Our ref: DOC20/883996-7

Notice of Exhibition of application for EnergyConnect (NSW – Western Section) (SSI-10040)

Thank you for your referral dated 27 October 2020 inviting comments from the Heritage Council of NSW on the above State Significant Infrastructure (SSI) proposal.

Dr Siobhan Lavelle OAM
Senior Team Leader
Specialist Services
Heritage NSW
Department of Premier and Cabinet
As Delegate of the Heritage Council of NSW

Figure 3-3

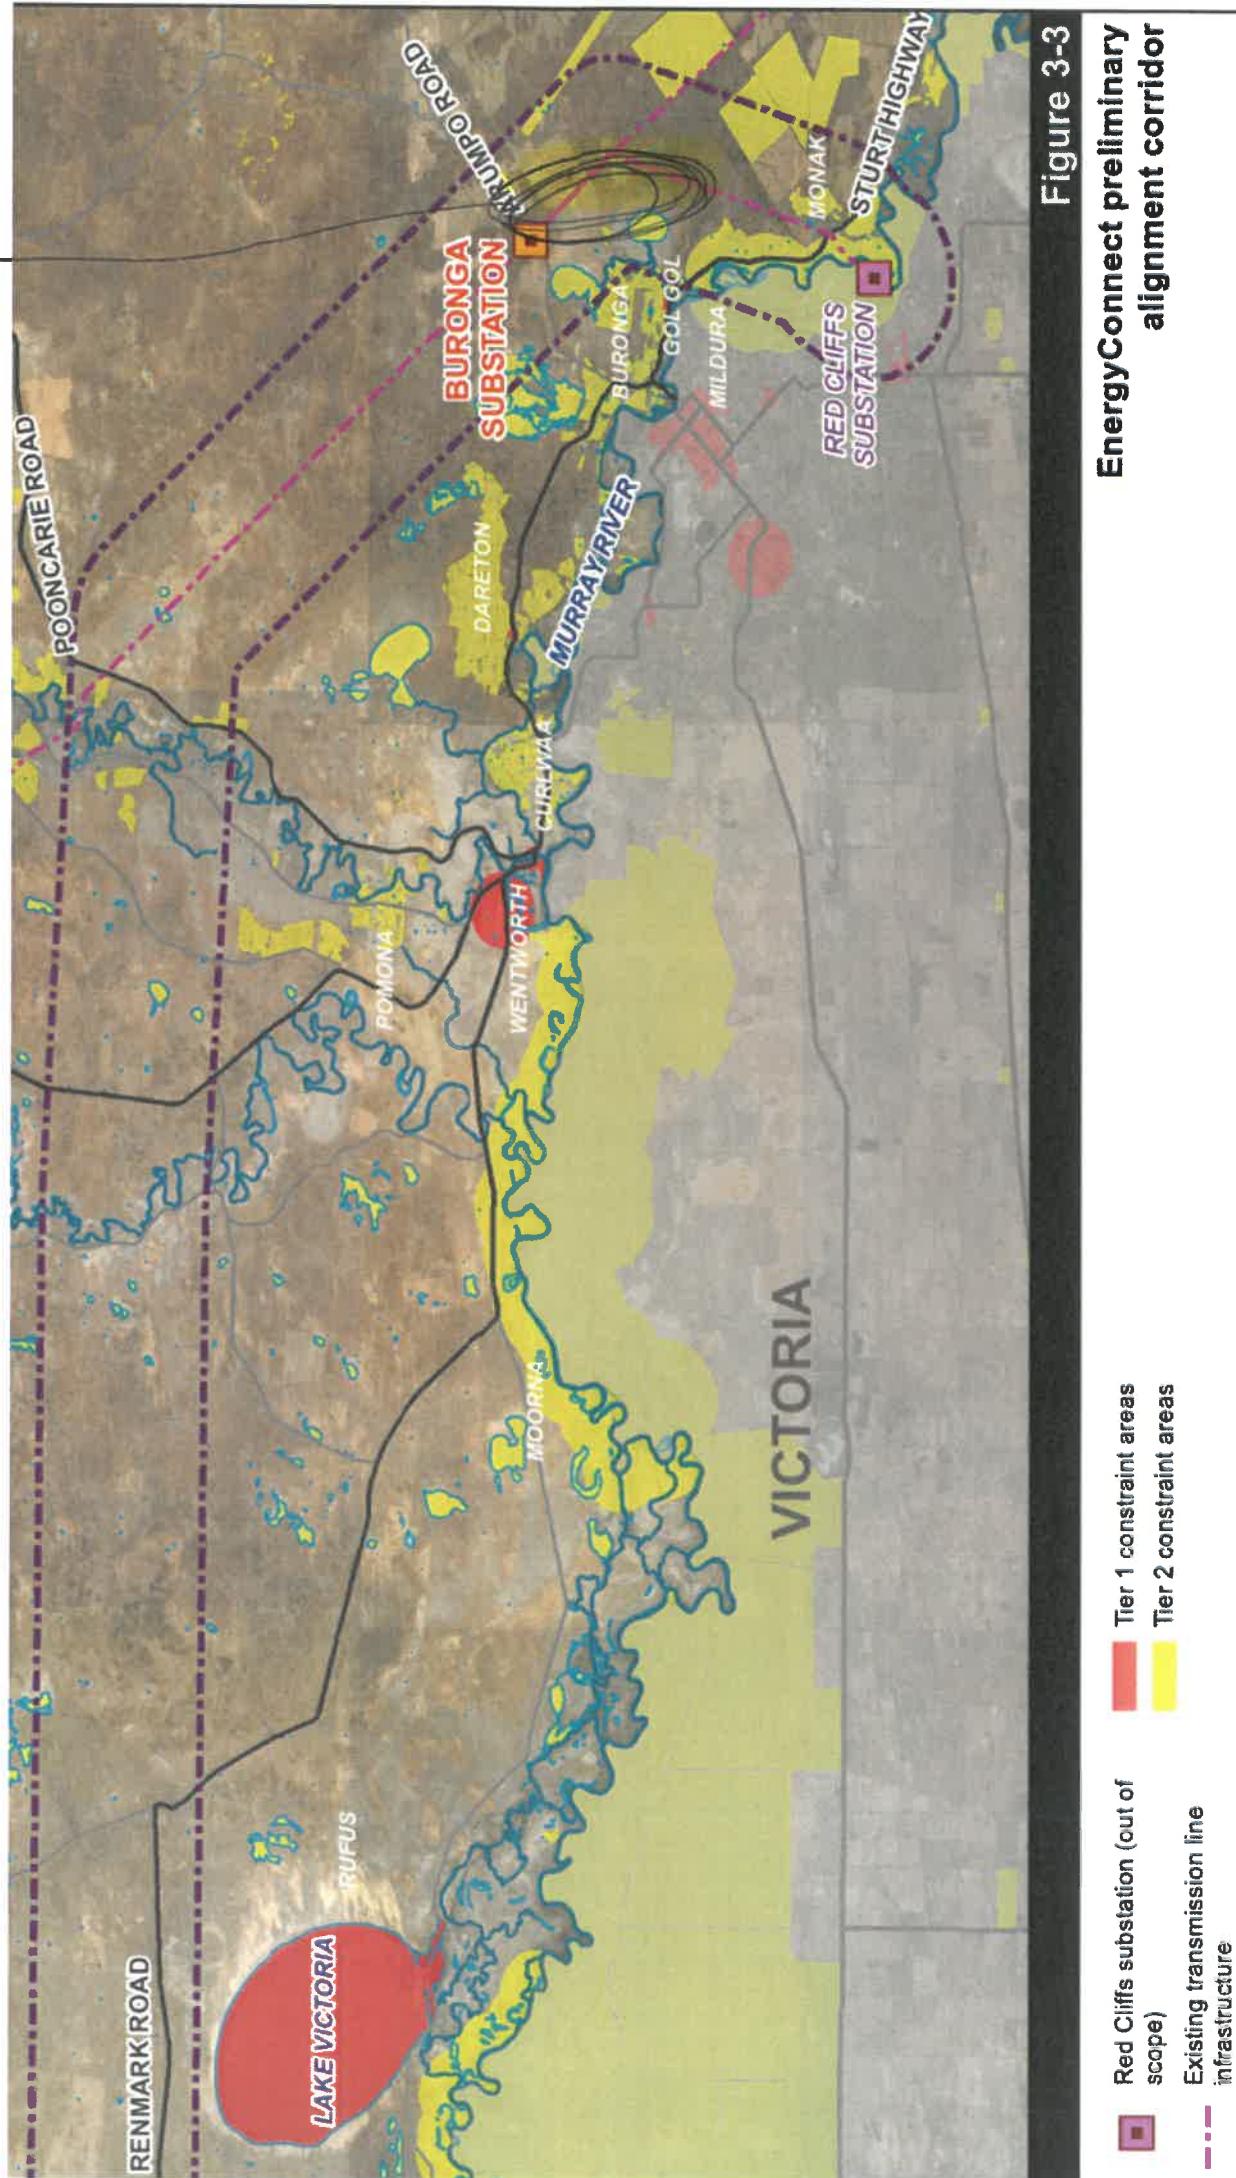
- The proposal passes through the curtilage of three heritage items of local significance: Nulla Nulla Woolshed (I81), Nulla Nulla Homestead (I82) and Sturts Billabong (I27). The heritage items are not identified as having archaeological potential. No ground disturbance is proposed within the curtilage of the heritage items.
